Application No: FP/108/20/HH
Site Address: 26 Roundle Avenue Felpham PO22 8LL
Description of works: Proposed 2 Storey extension to the South elevation with pitched barn hip roof, small dormer to North Elevation.

Thank you for your internet representation made on 15th July 2020 which has been recorded as an objection with the comments as follows:

## Proposed Plans and Elevations

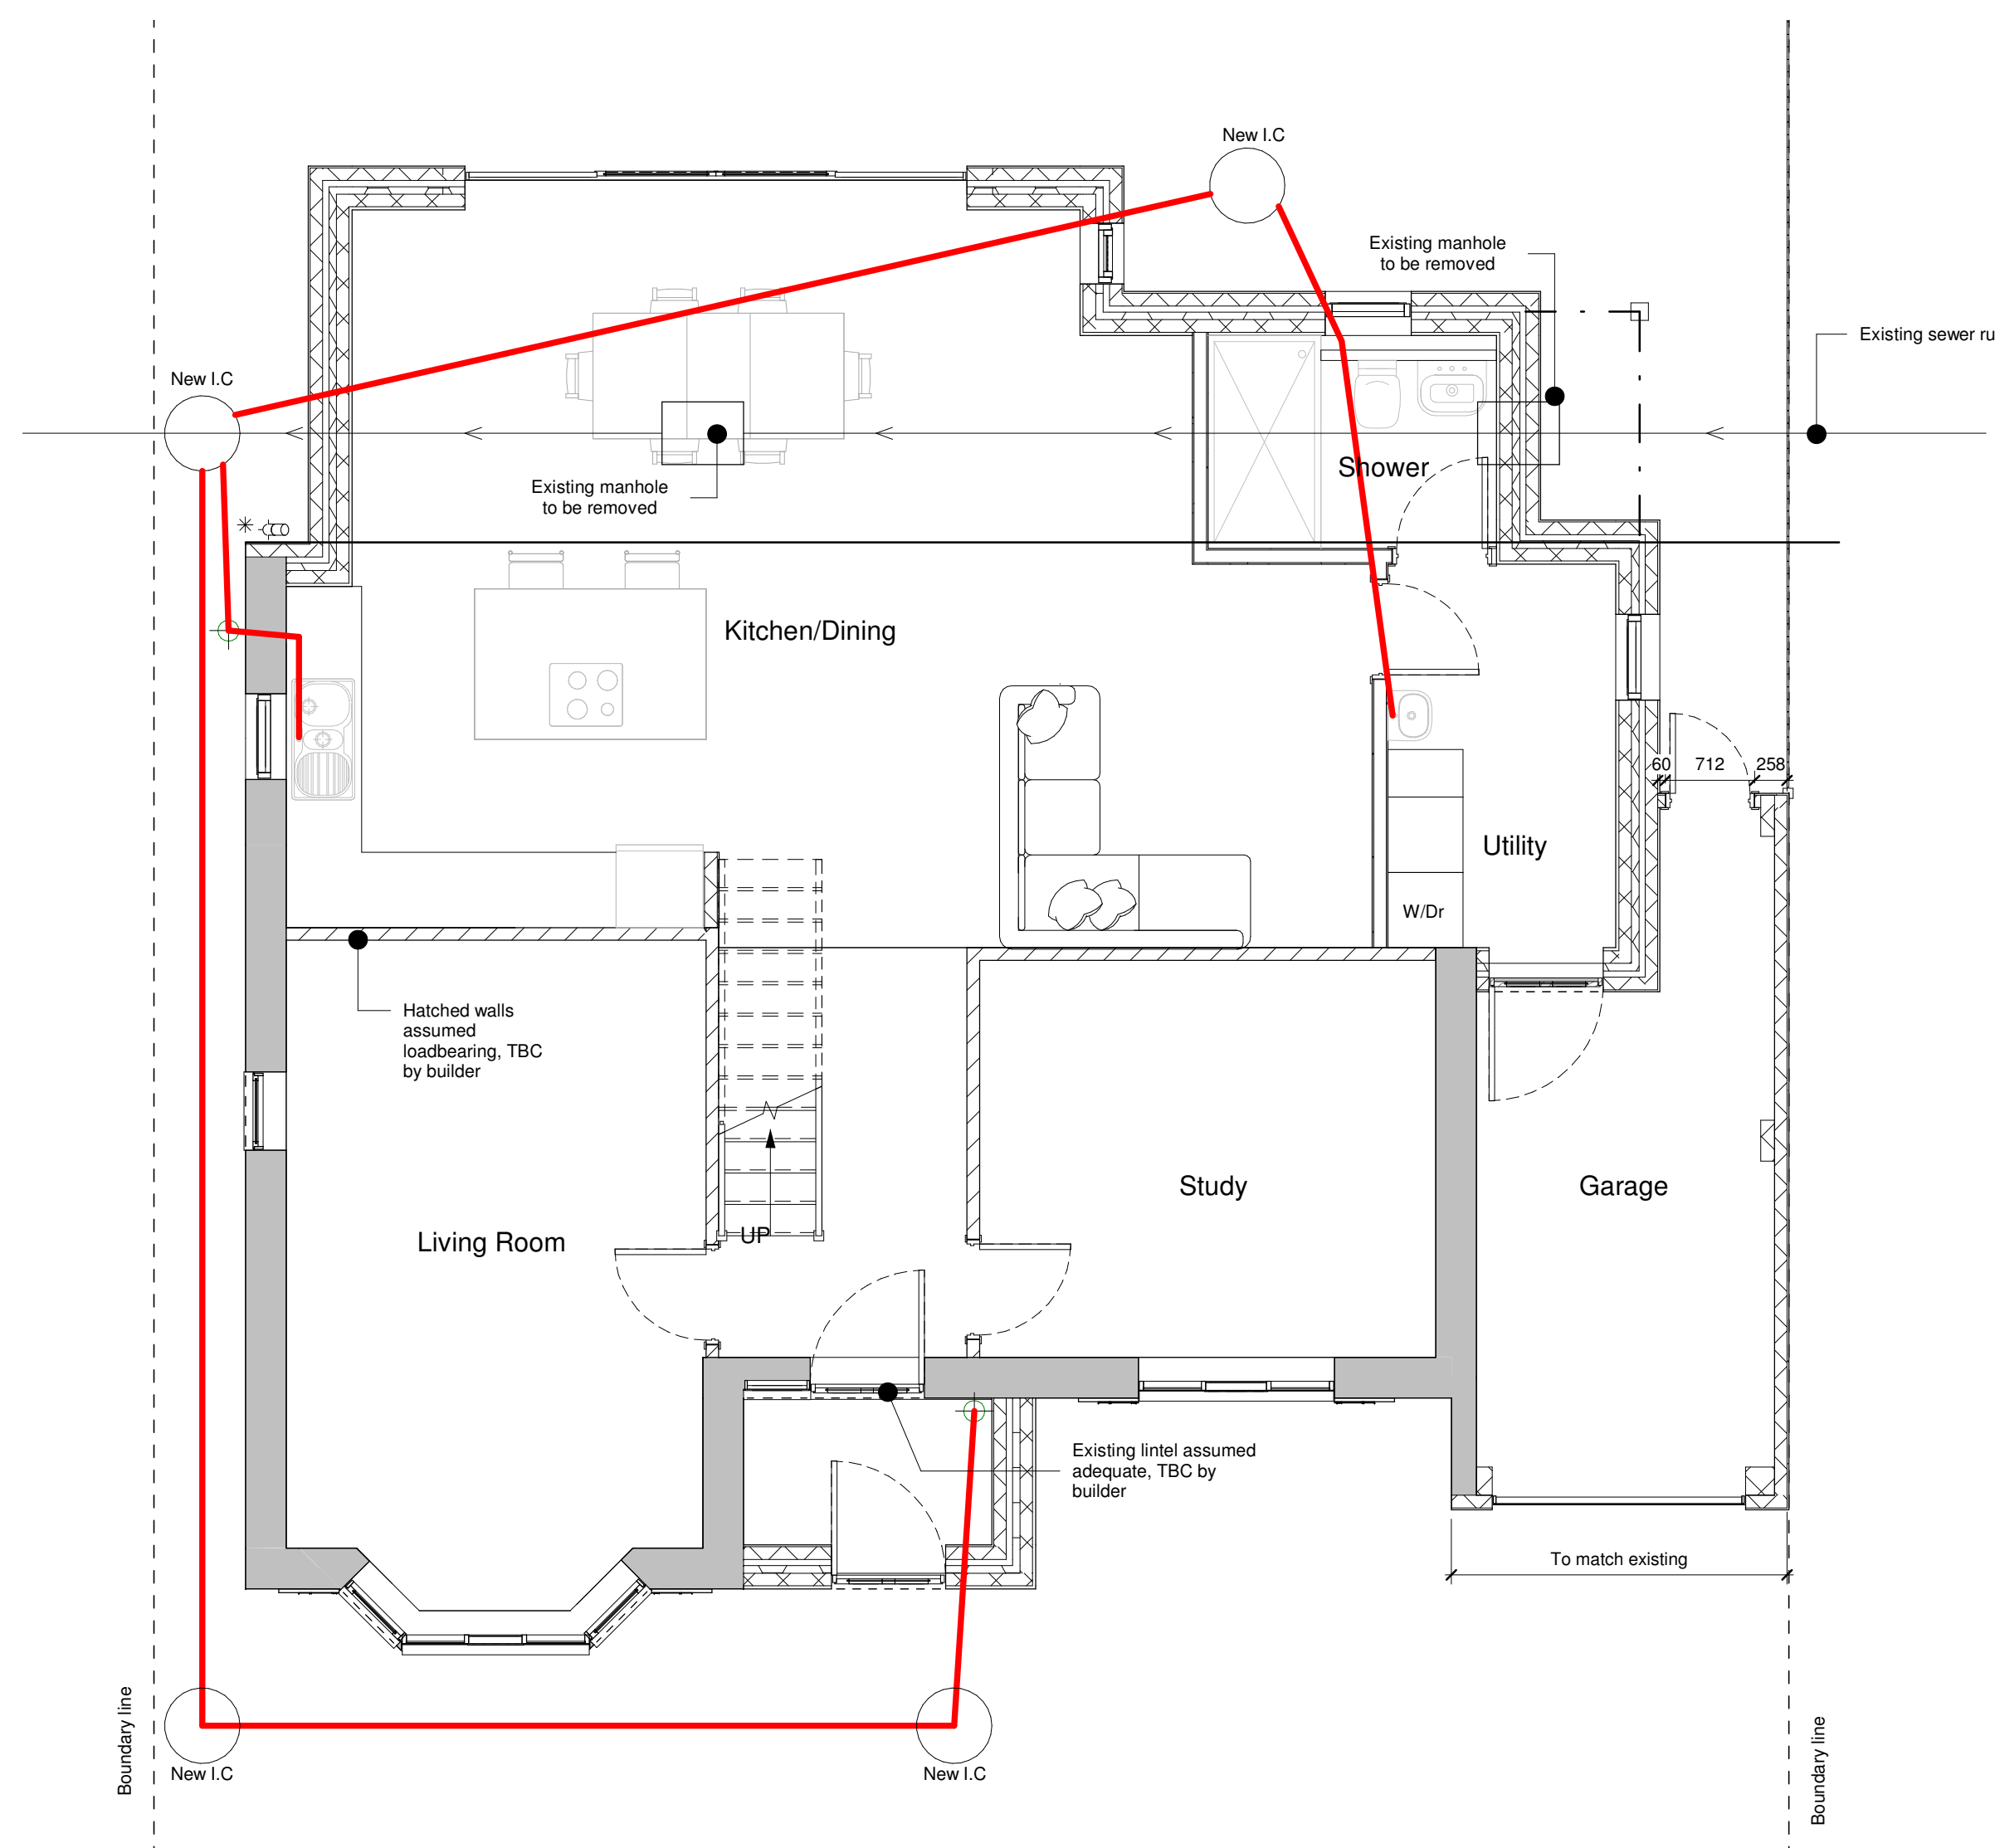
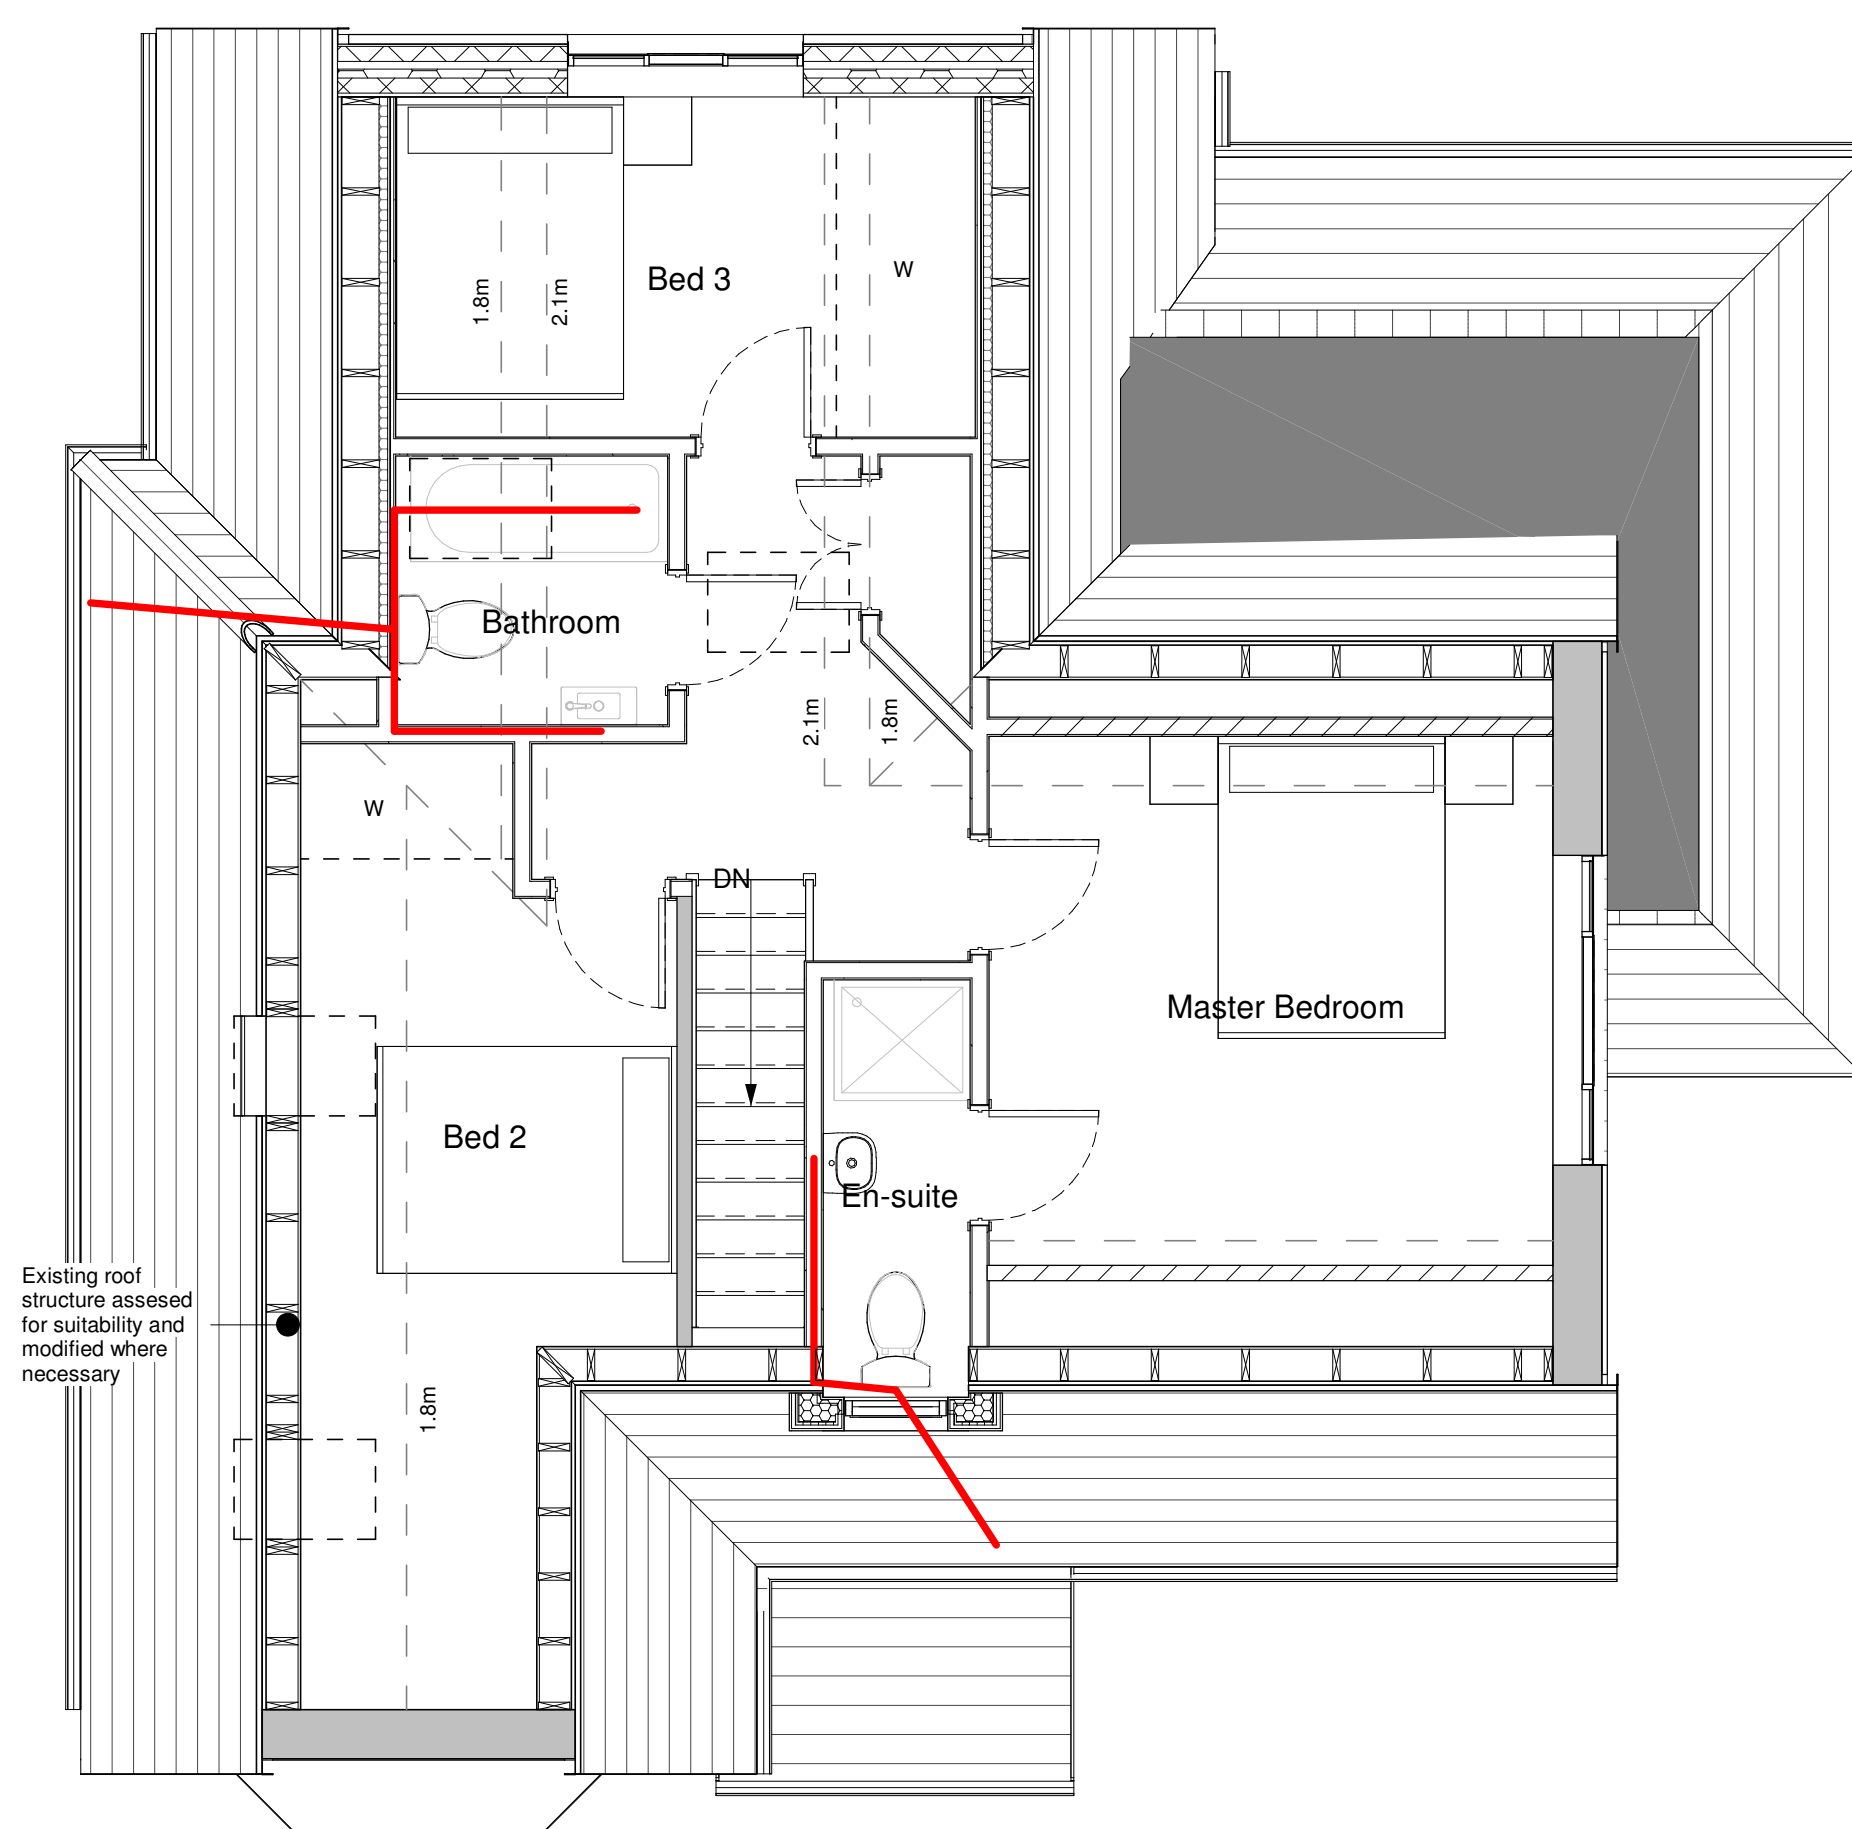
Object. On the application's drawings it is unclear if this is 1m from the boundary.
